Submission No.			098	
Organisation Name or Name of Submitter			Frank McDonald (6 The Cedar Glensavage Avoca Road, Blackrock)	
Item No.	Section Ref.	Page No.	Observation Statement	TII Response
RE: Railway Order application for Metrolink project (ref 314724)				
1		3	In reality, however, it is a classic example of the absence of joined-up thinking on transport in Dublin — a stand-alone project that doesn't make sense in its own terms and would need to be extended southwards in order to do so. An Bord Pleanála is, therefore, in the invidious position of being asked to make a decision on part of a much larger project without having any idea of where the rest of it would go.	As outlined in EIAR Chapter 03 (Background to the MetroLink Project), three major public transport projects proposed under the Transport Strategy for the GDA 2016-2035 (NTA, 2016), namely MetroLink, BusConnects and DART+ have been developed as independent standalone projects. These continue to be supported by the Transport Strategy for the GDA 2022-2042. However, these projects (together with the existing transport network and other public transport projects) are designed to provide a fully integrated transport netw

TARA STATION

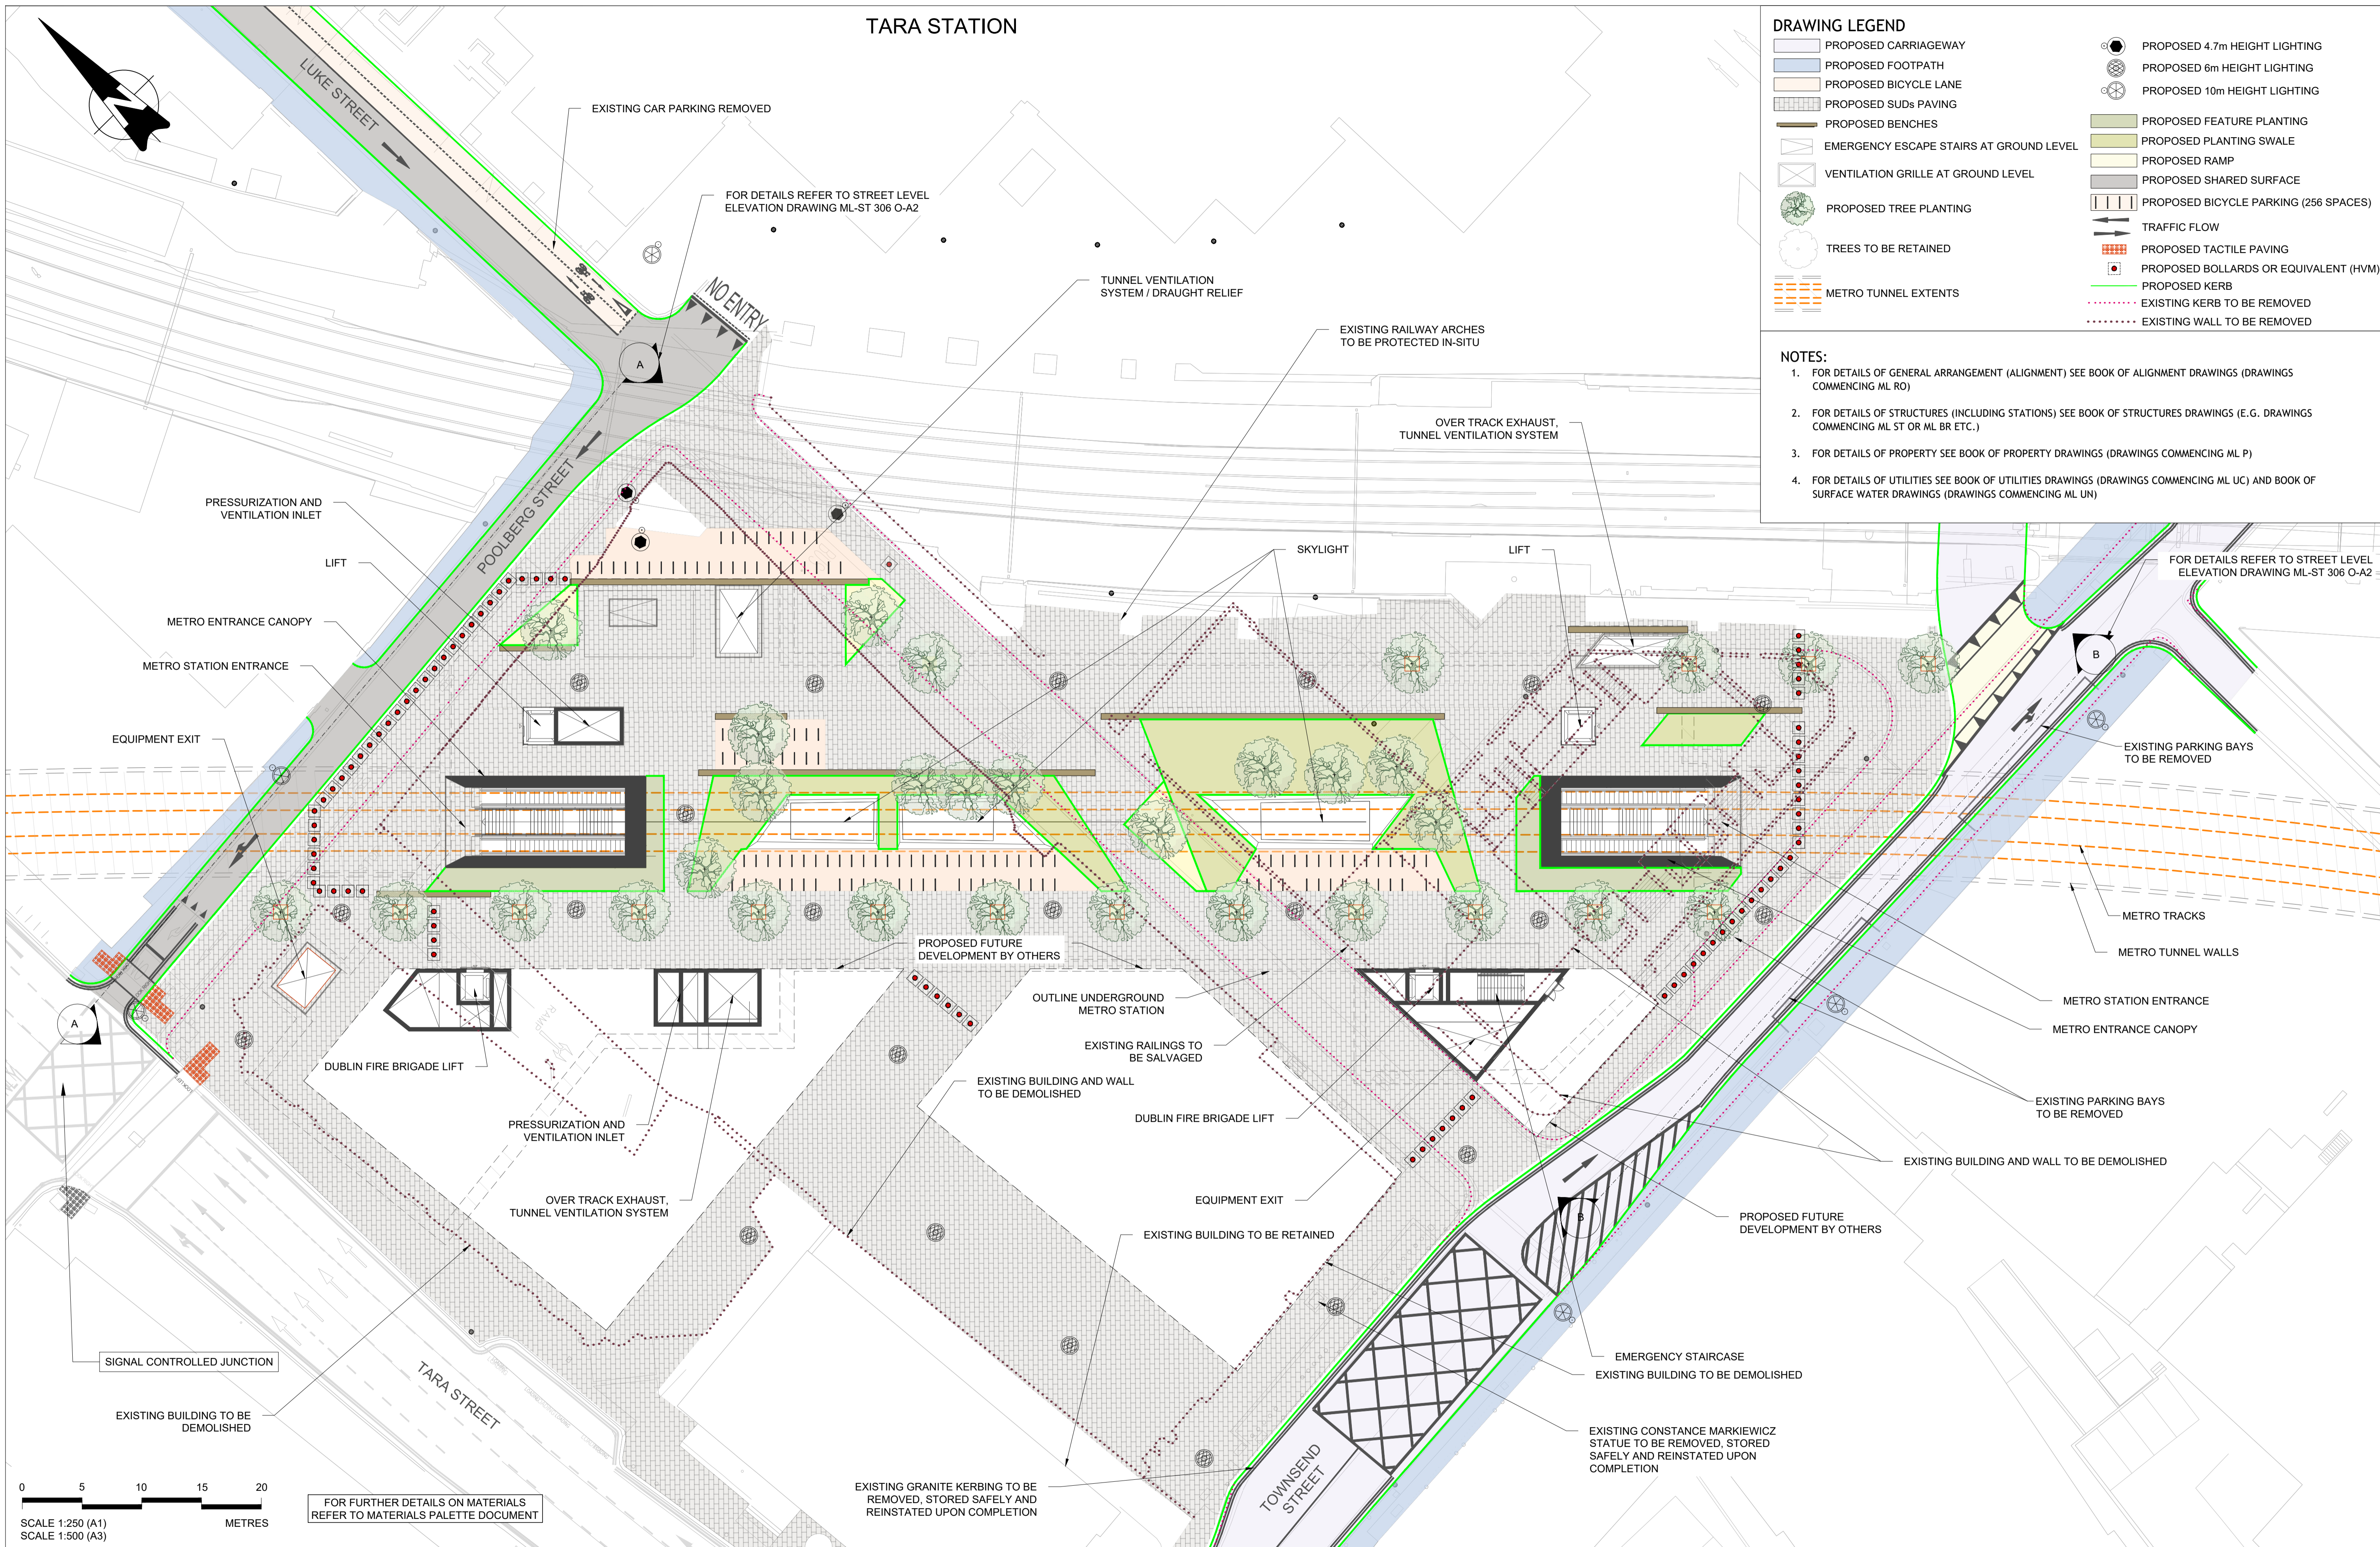
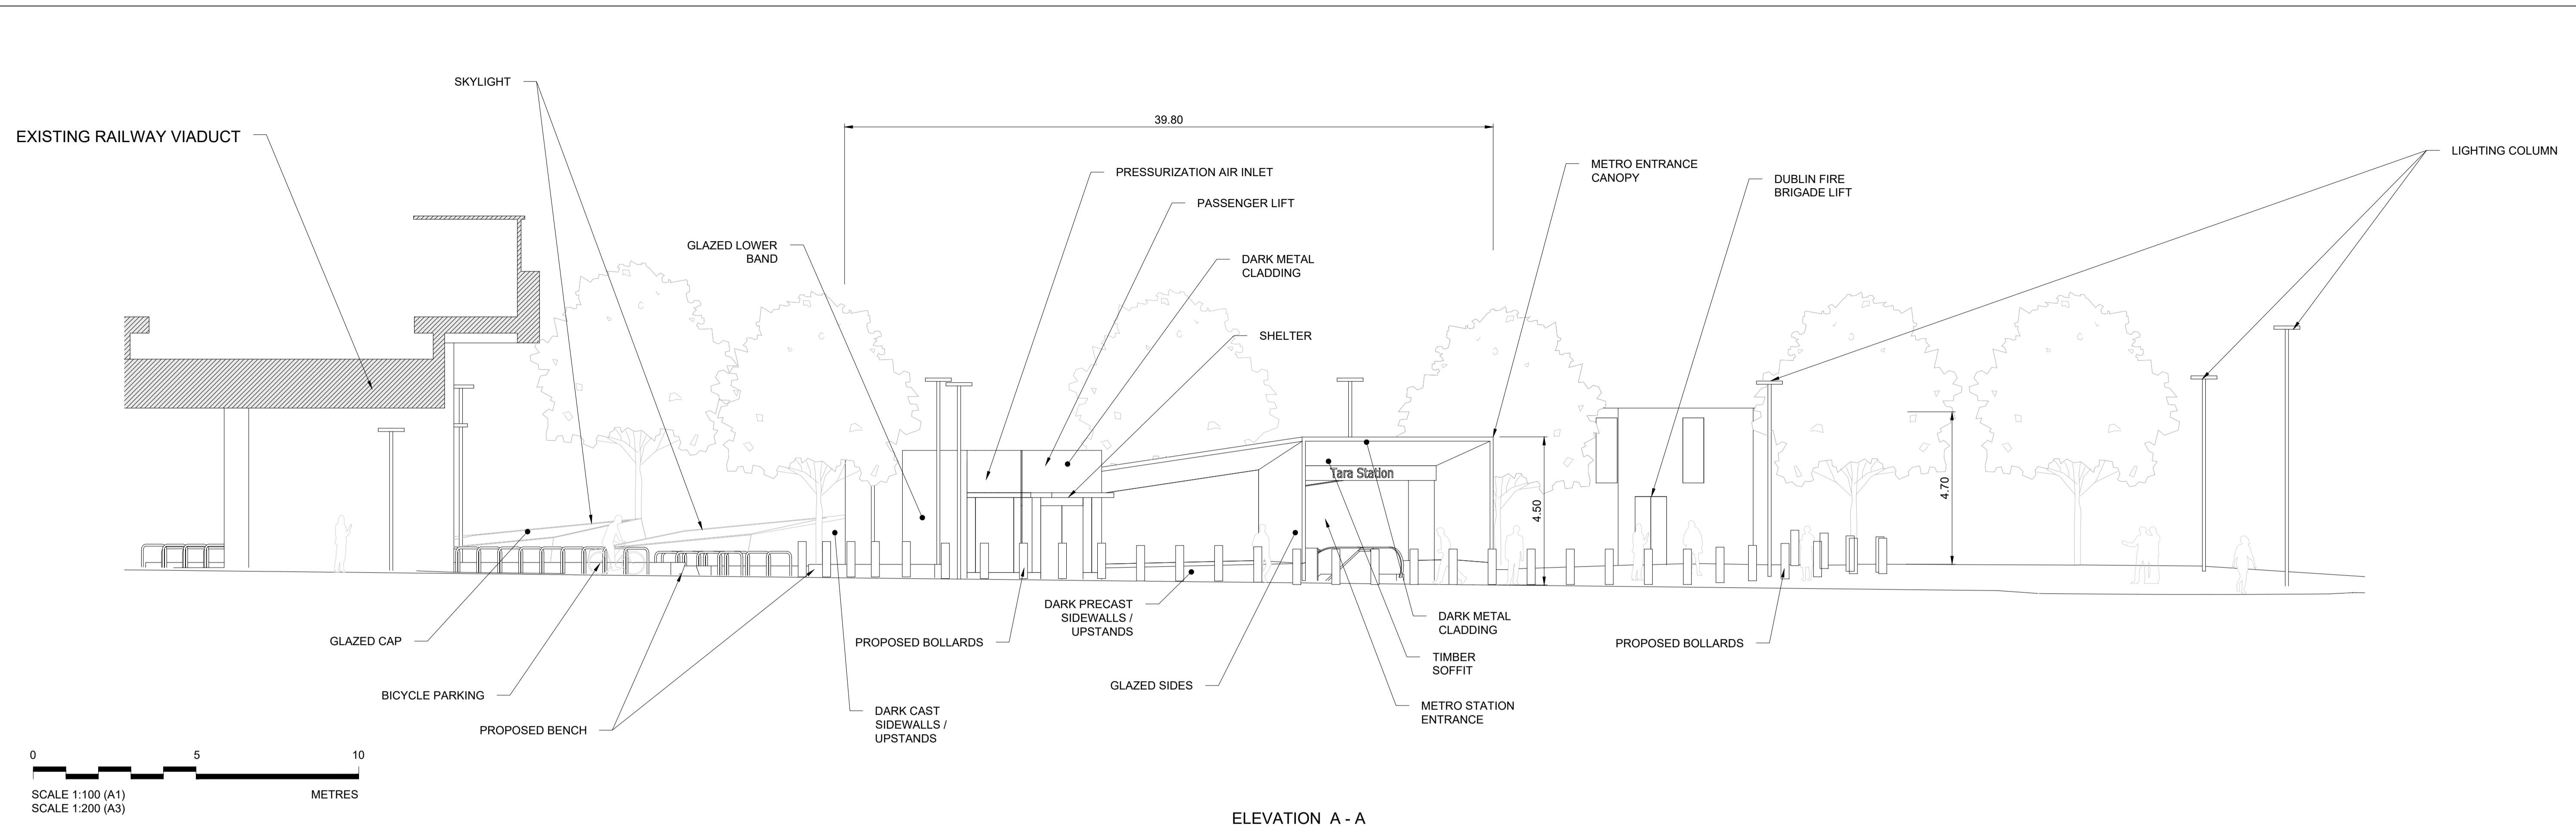
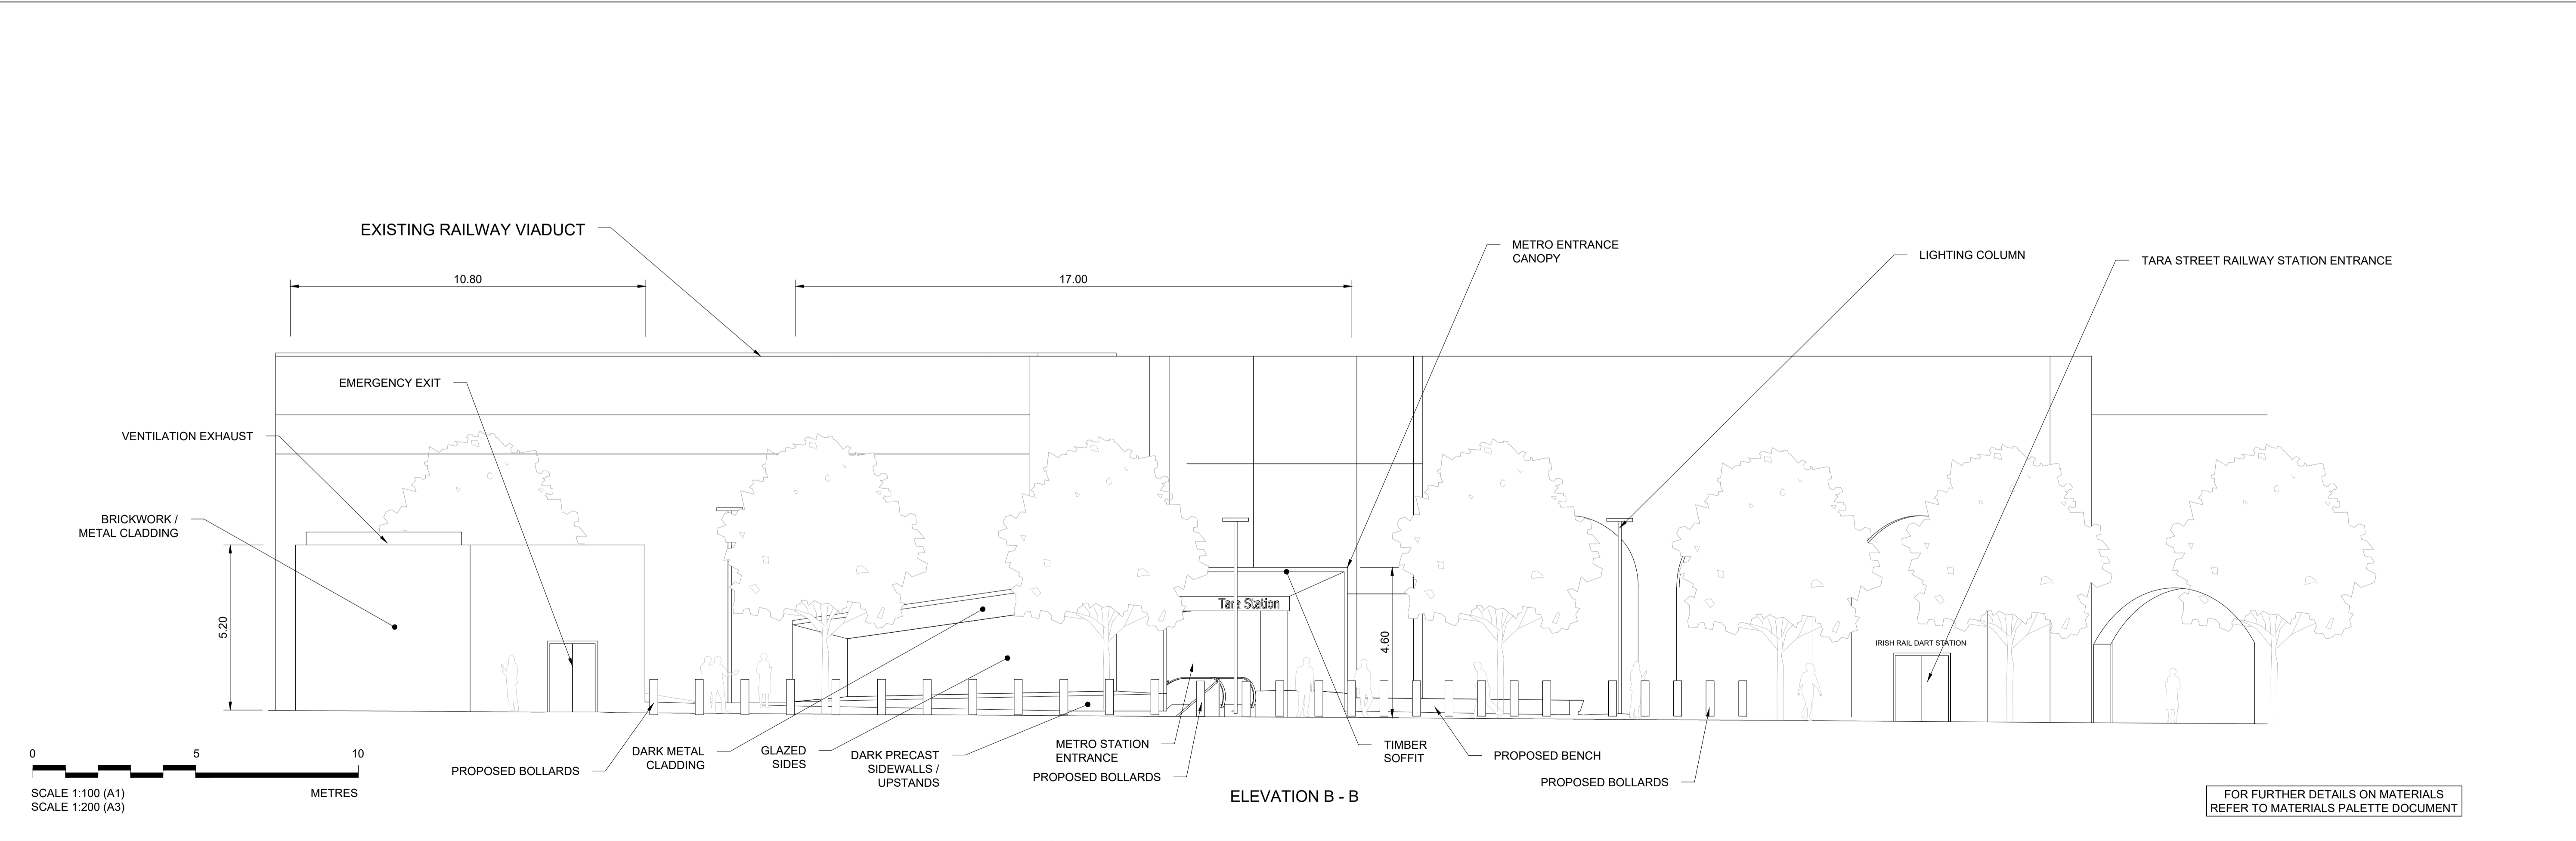
15		8	Ashford House on Tara Street, a substantial eight-storey office block dating from the 1990s, is also targeted for demolition to make way for the excavation of the Tara station — all as a direct result of the project promoters’ decision to divert the MetroLink alignment further east to provide a multi-level connection with the overground Tara Street DART station.	Please refer to response item (5) above in relation to the justification of Tara Station location.
16		8	<p>It should be noted that the entire city block bounded by Tara Street, Poolbeg Street, Hawkins Street and Townsend Street has been cleared in recent years for redevelopment. Had the alignment been drawn differently, it would surely have been possible to provide a station box for Metrolink on that extensive site. However, it appears to have been overlooked by TII/NTA.</p> <p>Instead, an equally large urban block immediately to the east — bounded by Tara Street (with the sole exception of the Irish Times building), Townsend Street, the Loopline and Poolbeg Street, and incorporating much of Luke Street — is now slated to be turned into another huge hole in the ground for several years to facilitate construction of Metrolink’s Tara station box.</p>	Please refer to response item (5) in relation to the justification for Tara Street Station. EIAR Appendix A7.2 Tara Street Station Report summarises the options considered for the location of Tara Station. In total 11 options were considered, which included various alignments which would locate under other sites referenced in the submission, however the preferred option 0, now the proposed Tara Street Station location, was selected as the preferred option as it retains good interchange facility with DART in line with the Project objectives, it has more limited impact on city traffic and utilities during construction than other options, it reduces risk to the overall construction programme, provides for a safer construction methodology, offers a cheaper overall construction cost, and retains the opportunity for future adjacent development by others.
